From: Nick Goddard
Sent: 25 May 2017 13:48
To: DCAdmin
Subject: 2017/91047 Former Fire Station, Scout Hill

Nick Goddard
Arboricultural Officer

Title: **Proposed Site Plan**

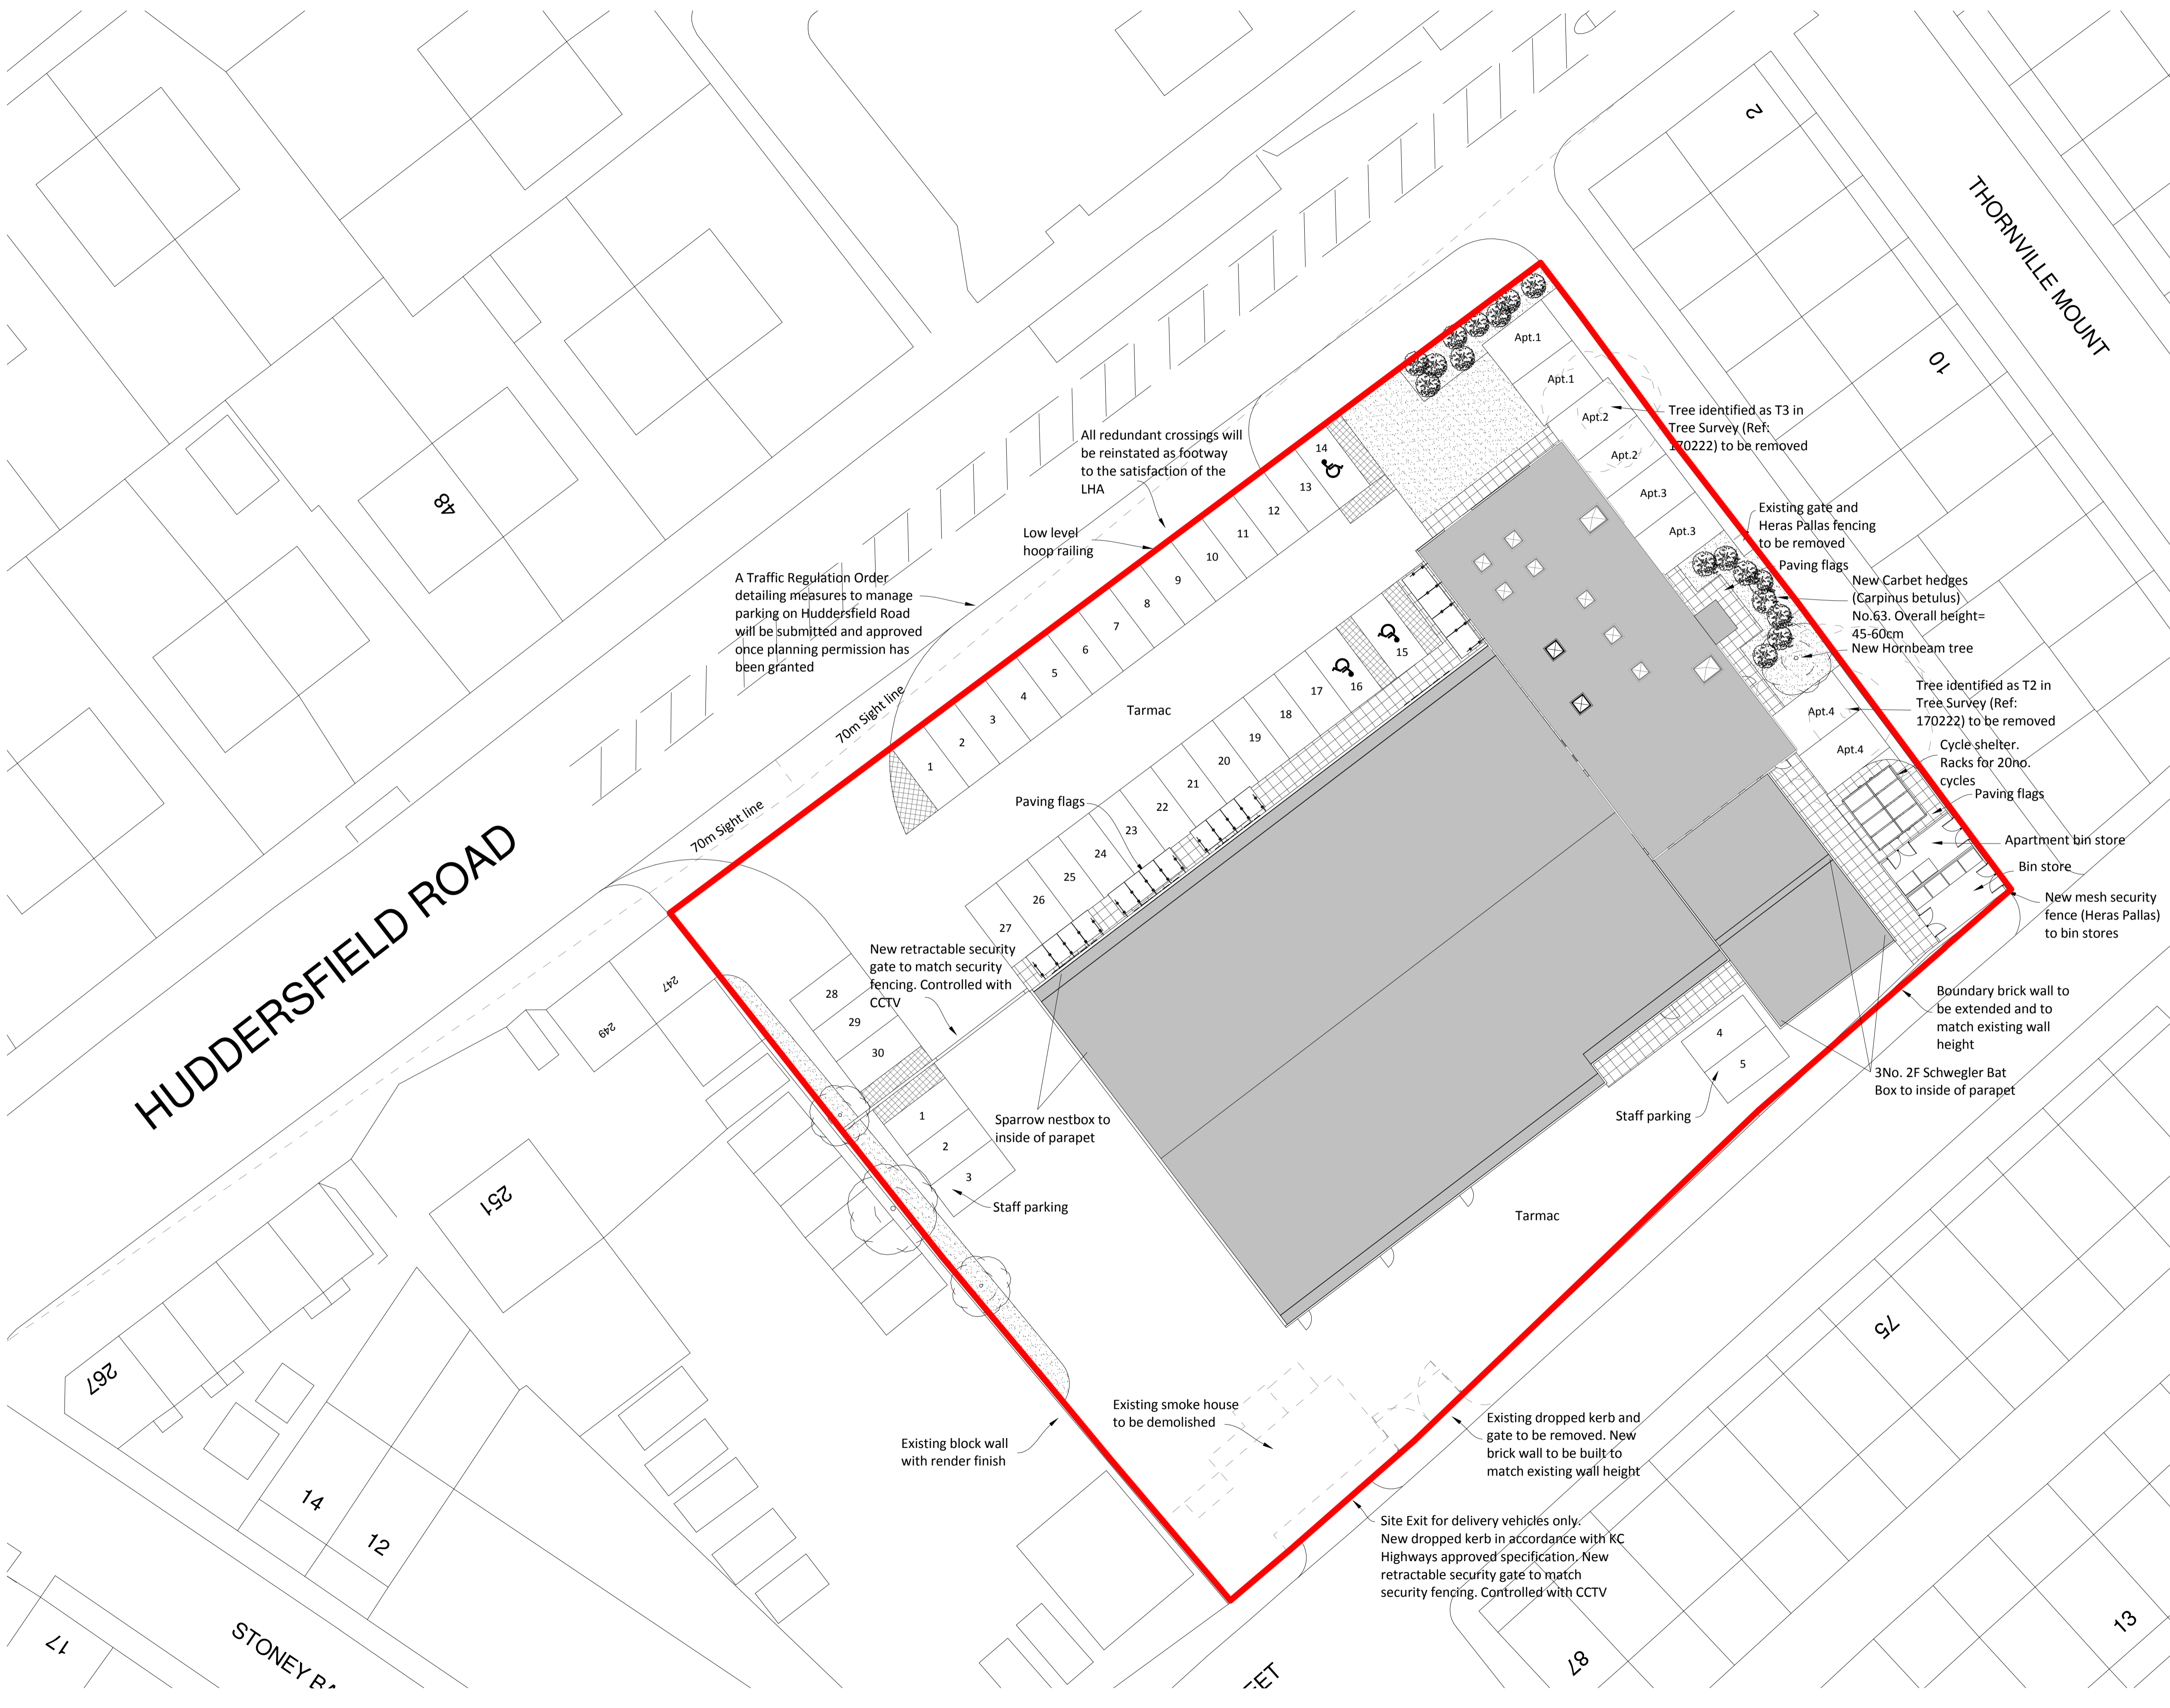
I have no objection to the proposals. The proposals show the removal and replacement of one tree however there is much more room for tree planting within the proposals which should be taken advantage of to improve the streetscene.

In addition the demolition and construction is likely to damage the adjacent cherry tree (T3) shown as retained. As this tree was in a poor condition I would rather this tree be replaced with another Hornbeam in the same place. This would allow more room for the works to be carried out and ensure the long term benefit of a good quality tree in this position for the future.
